**ENVIRONMENTAL ASSESSMENT EXHIBITION FOR MIXED USE BUILDING AT 6-16  
ATCHISON STREET, ST LEONARDS (MP09\_0187)**

Transport NSW has reviewed the Environmental Assessment (EA) report and appended Traffic and Parking Study (the 'Study'). The following comments are provided on specific aspects of the proposal and should be reflected in the final statement of commitments and potential future conditions of consent:

David Hartmann  
**A/ Senior Manager**  
**Centre for Transport Planning and Product Development**

TTM Reference: **80606**

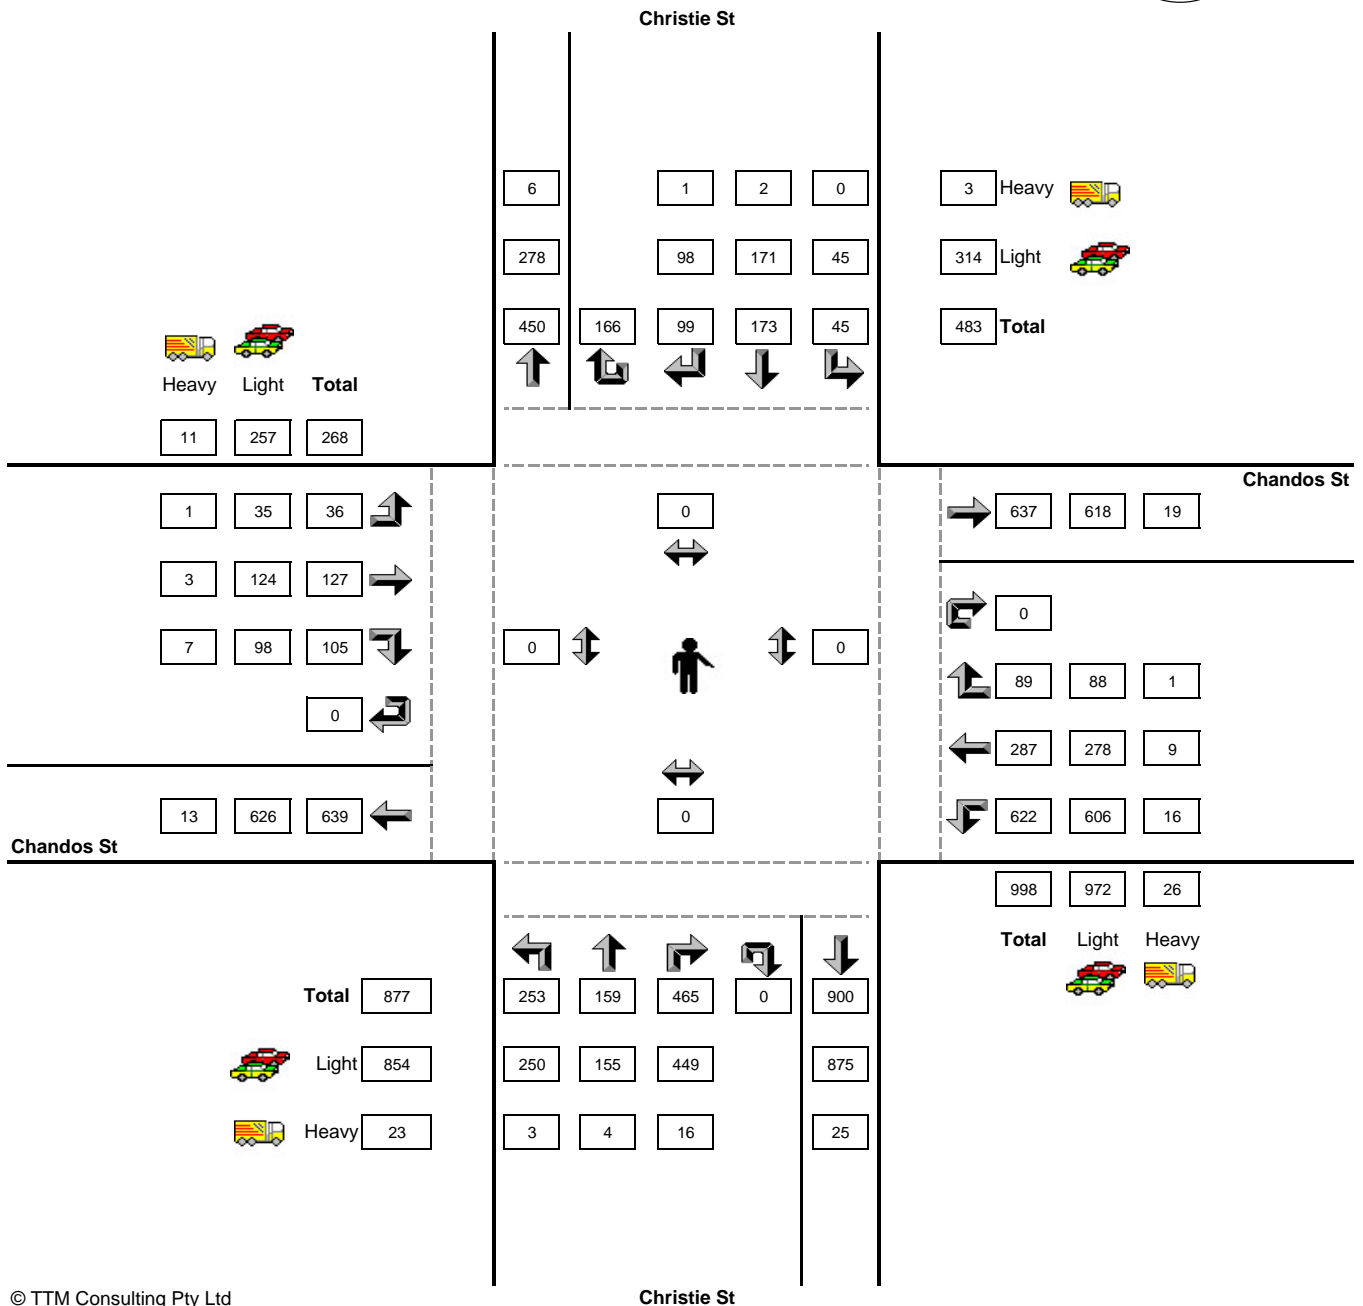
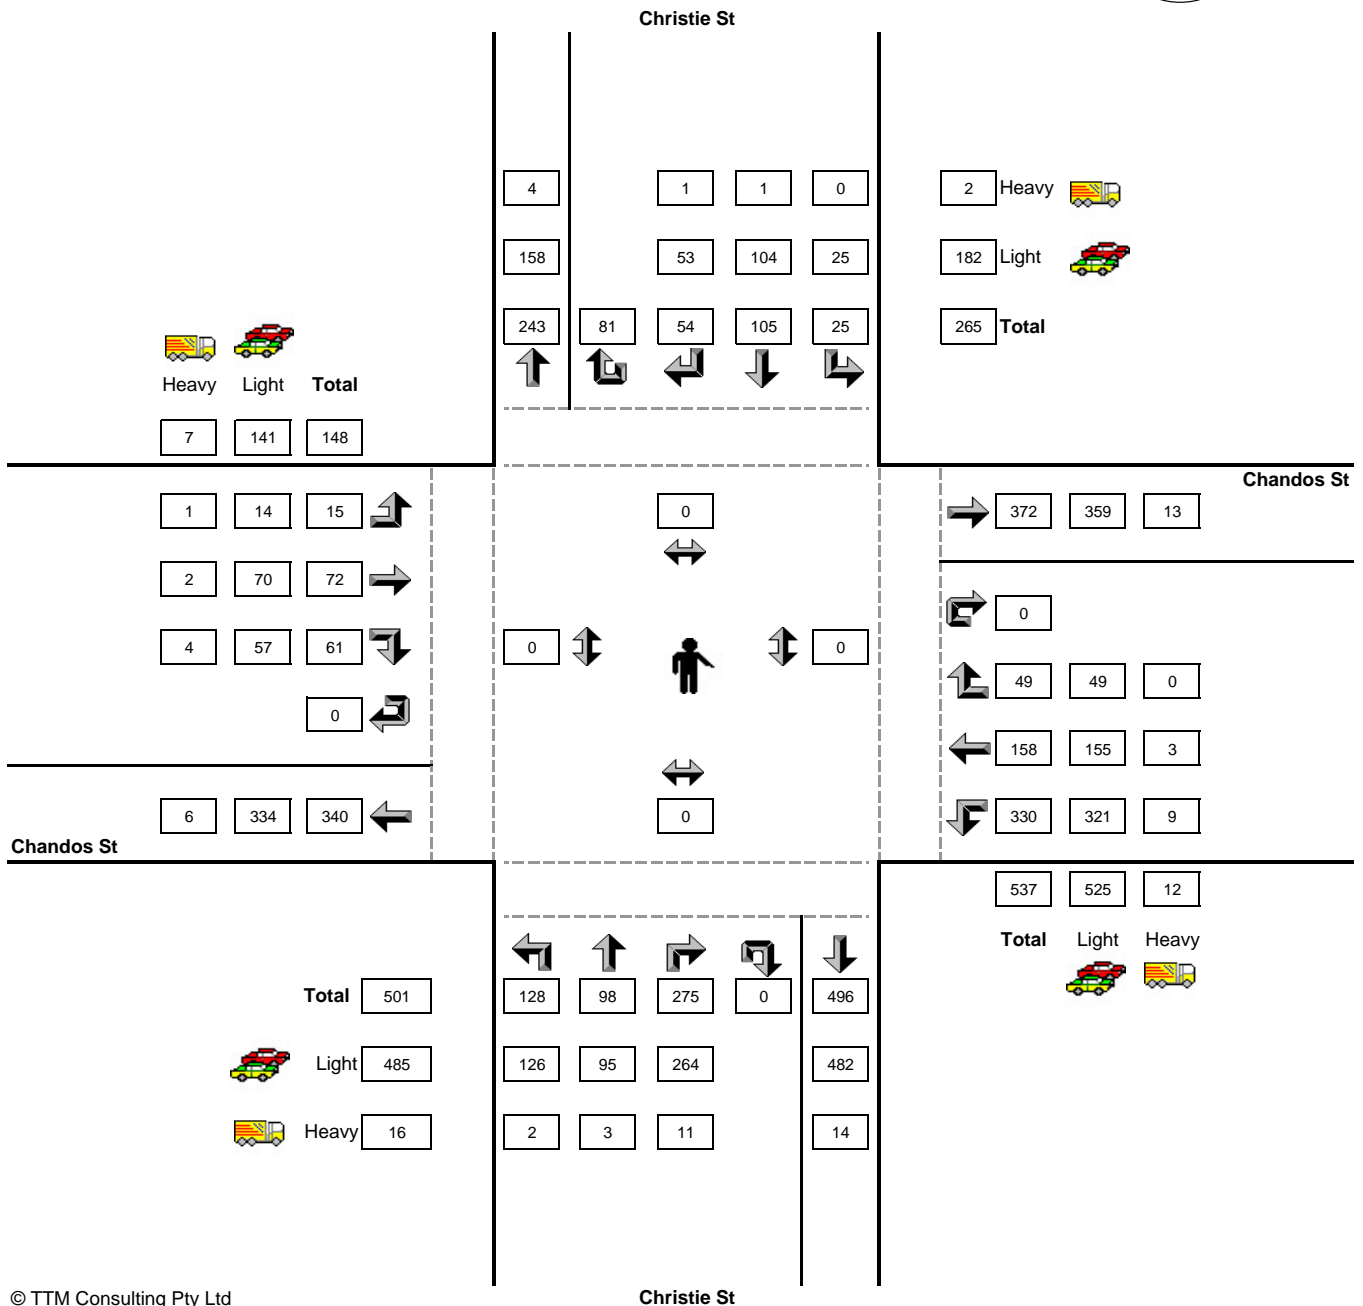
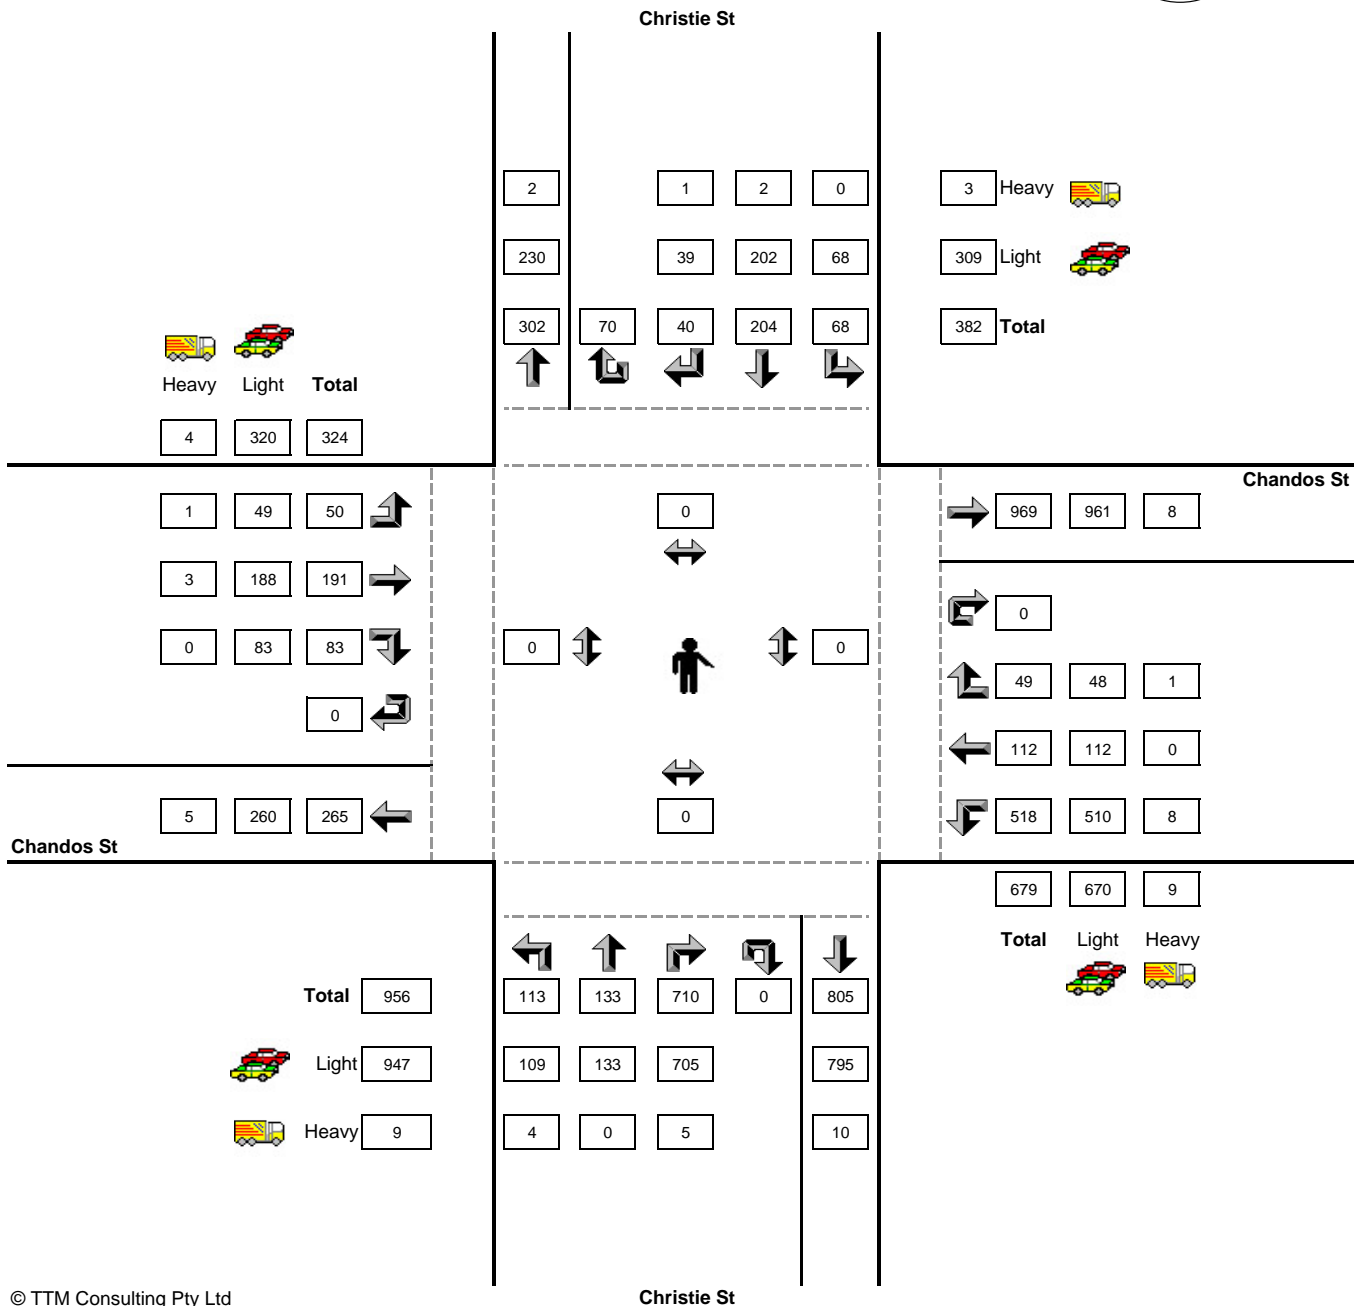
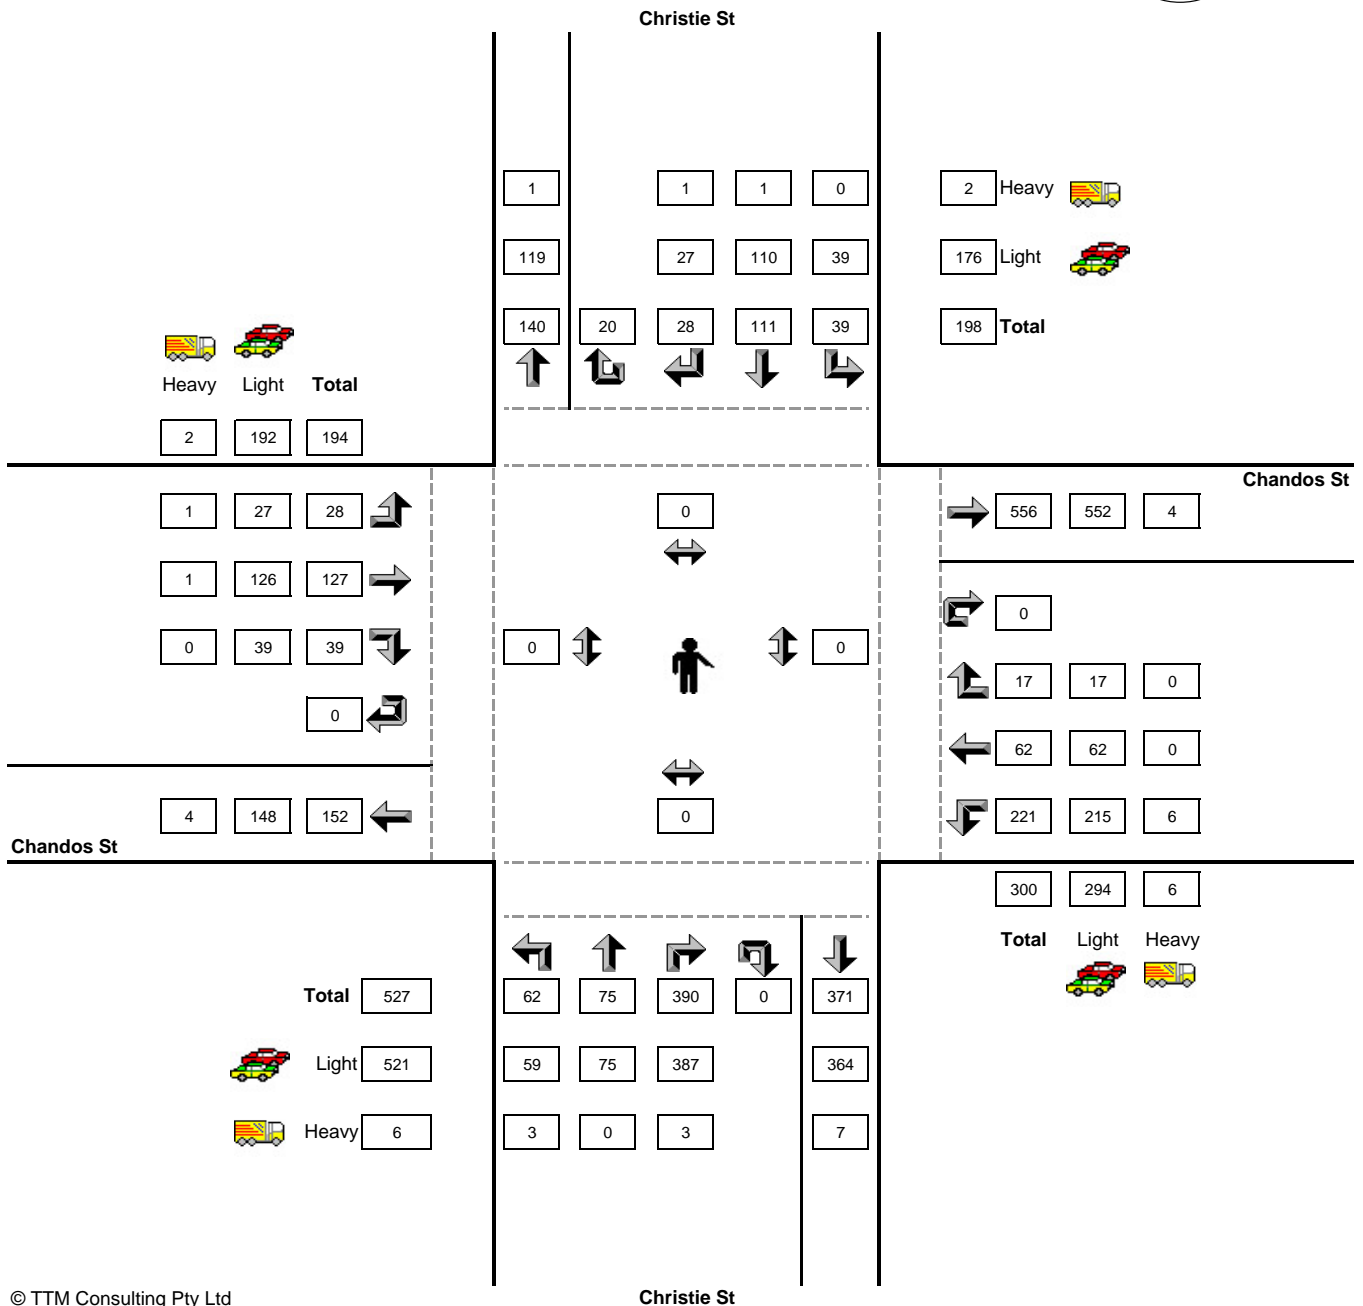
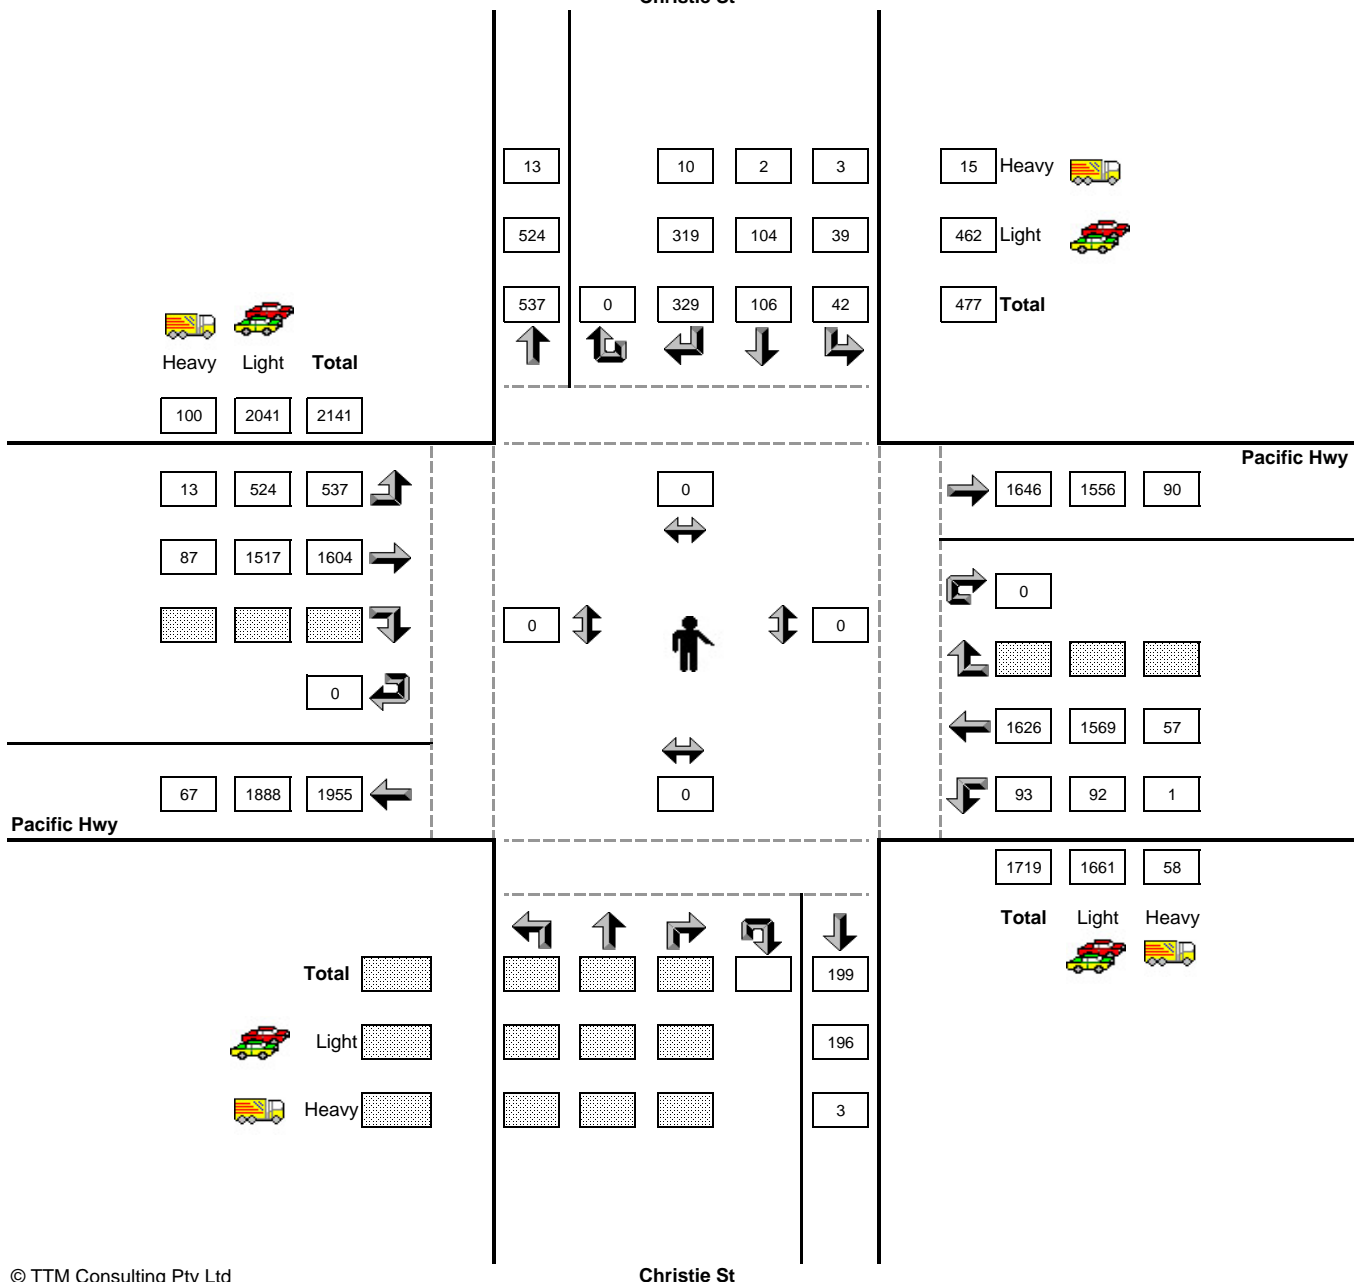
- Transport NSW queries the TTM Group pedestrian survey results that record no pedestrian activity within the survey period. Further consideration of pedestrian impacts and facilities is recommended.
